PCD FILE NO. SF-19-022

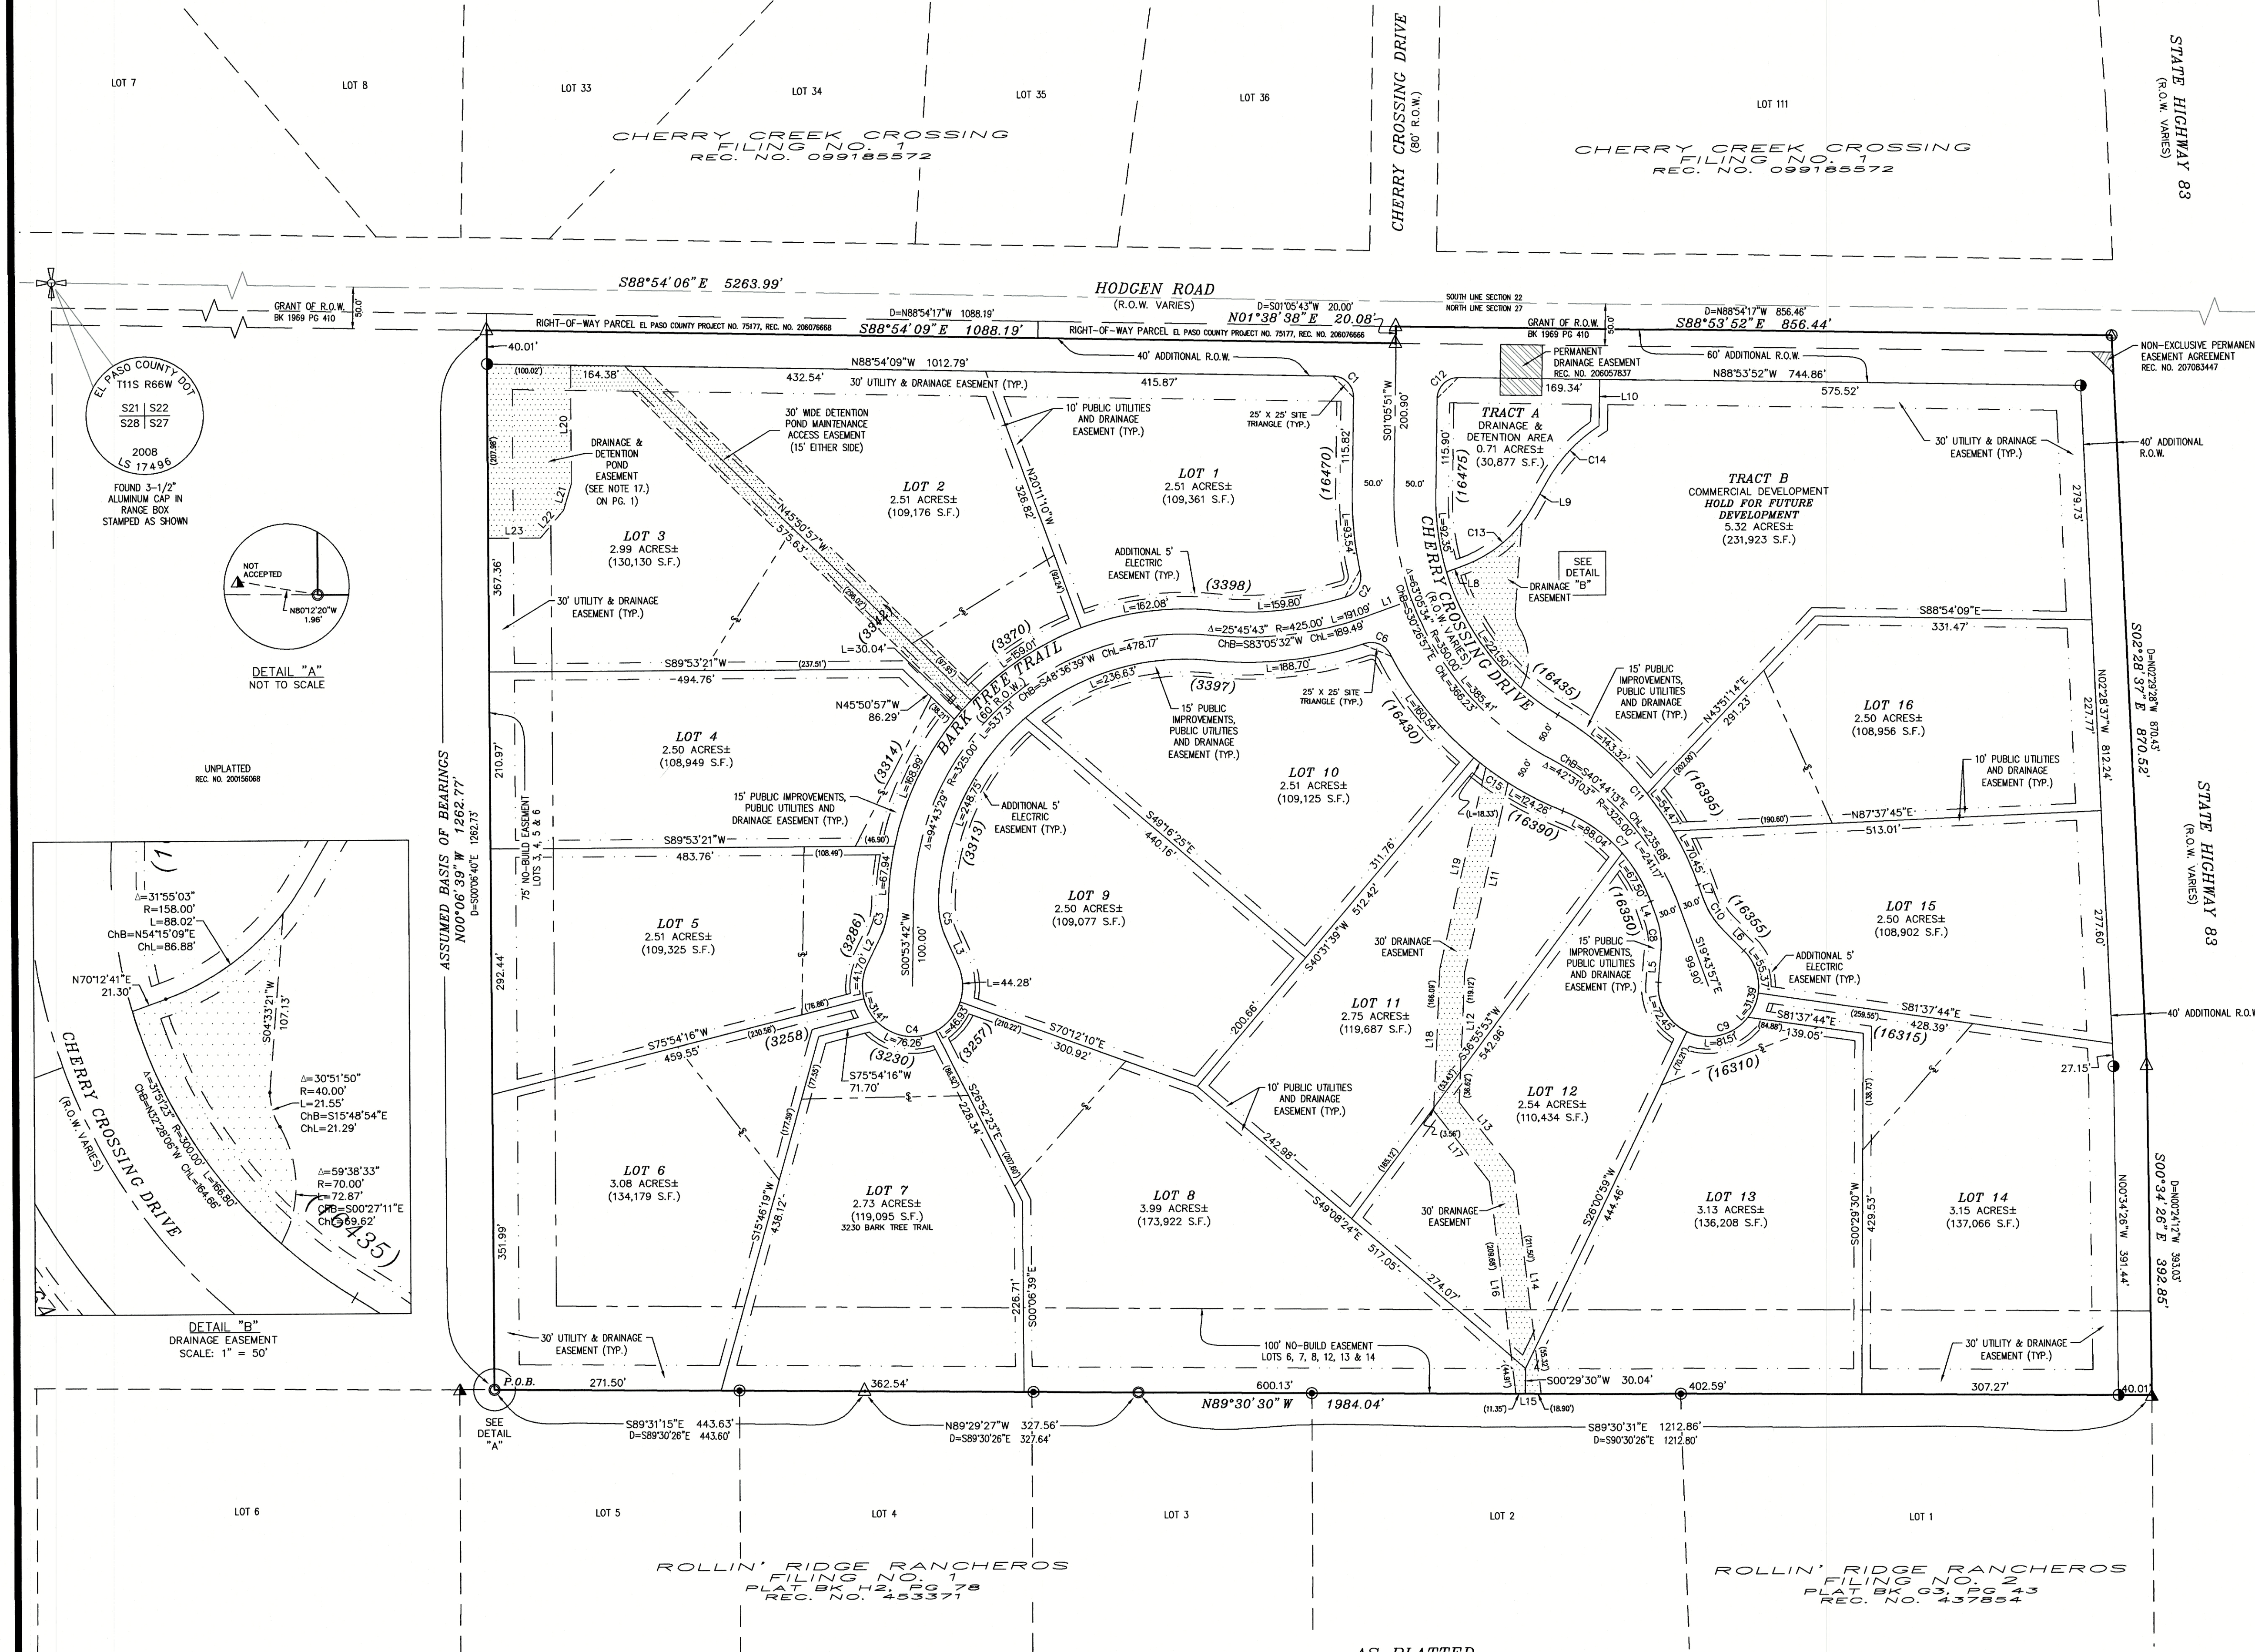
Notes below are needed or modified and added.
Also, there are no notes in regards to the HOA and Declaration of Covenants, please include.

Add the following notes:
1. There shall be no direct lot access to Hodgen Road and State Highway 83. There shall be no direct lot access to Cherry Crossing Drive for Lot 1.
2. Individual lot purchasers are responsible for constructing driveways, including necessary drainage culverts from Bark Tree Trail and Cherry Crossing Drive per Land Development Code Section 6.3.3.C.2 and 6.3.3.C.3.
3. Lot 3 and Tract A is subject to a Private Detention Basin/Stormwater Quality BMP Maintenance Agreement and Easement as recorded at Reception No. _____ of the records of El Paso County. The _____ HOA (or Owner or District) is responsible for maintenance of the subject drainage facilities.

8. THE PROPERTY IS SUBJECT TO EASEMENT(S) FOR THE PURPOSE(S) SHOWN BELOW AND RIGHTS INCIDENTAL THERETO AS GRANTED IN A DOCUMENT TO A NATURAL GAS COMPANY FOR PIPELINE PURPOSES RECORDED SEPTEMBER 18, 1961 IN BOOK 1882 A. **Revise note 15 to "No driveway shall be established" MARCH 24, 1970 IN BOOK 2336 AT P. 1008 AT RECEPTION NO. 208083871. (NOT PLOTTABLE)**

the 16 residential lots are not in the PUD development plan, they are however, covered by an HOA and Covenants

Under PUD Development, see note 9 comments
